The Parochial Church Council
Holy Cross Church
North Bersted
www.holycrossnorthbersted.org.uk

12 February 2017

**OBJECTION TO PLANNING APPLICATION NO: BE/180/16/PL
1 NO DWELLING – LAND ADJOINING 2 NORTH BERSTED STREET
BOGNOR REGIS PO22 9AD**

SITE PLAN
SCALE 1:200

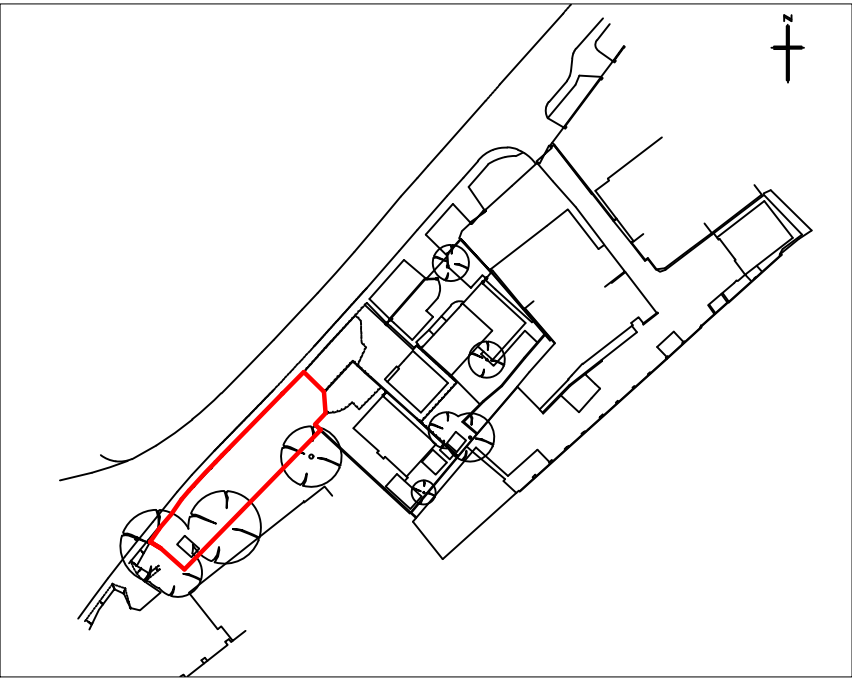
- The plan is incorrect – the existing entrance is not where it is shown on the plan. We have shown the actual location of the existing entrance on the enclosed plan for your information.

- The supposed existing entrance shown on the plan requires access over an adjoining property (shown on the plan as No 2 North Bersted Street) and there is currently a wall blocking entrance from there and also there is an electricity pole on the land – indeed the notice of this planning application is attached to that electricity pole.

- We remind you that there is a history of planning refusals for this piece of land.
- Our Community Centre, and Church, are used on a daily basis requiring access to and from the church car park which is shown on the attached plan by green hatching. The visibility splay for the car park is already small and to have a building and fencing on the site would further restrict this.

GROUND FLOOR PLAN
SCALE 1:100

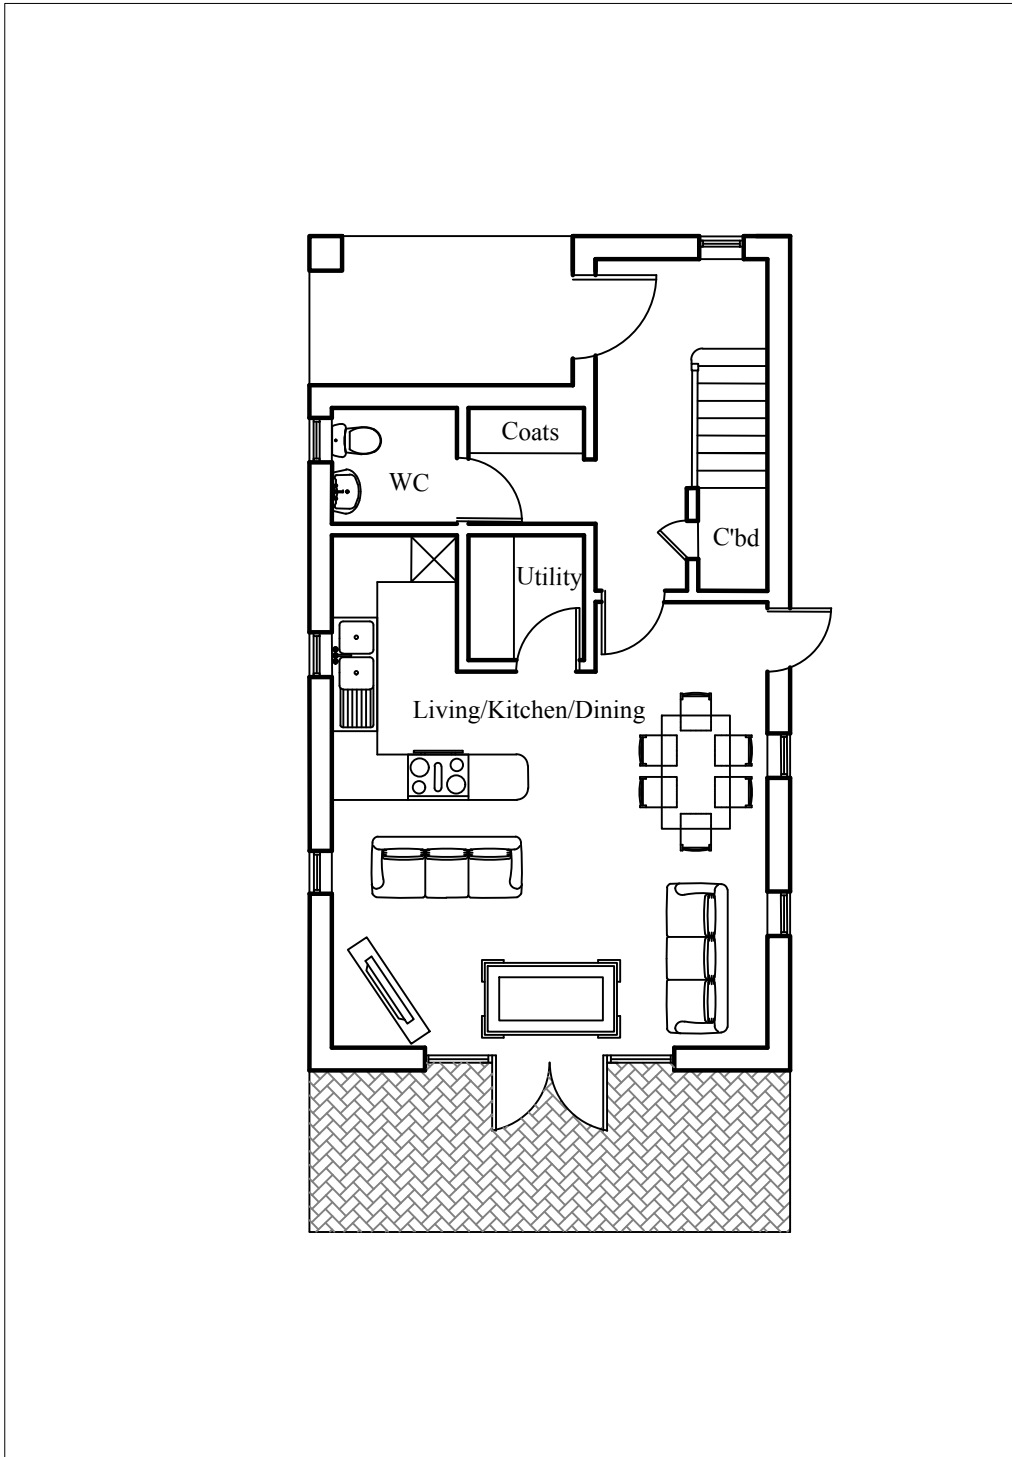
- The Community Centre is a valuable asset to the local community and as part of our outreach to that community it is used by the young, elderly and vulnerable in our community. We are concerned about security and the proximity of the proposed dwelling to the boundary fence of the Community Centre. No windows of any kind can be allowed on the side of the dwelling overlooking the Community Centre.
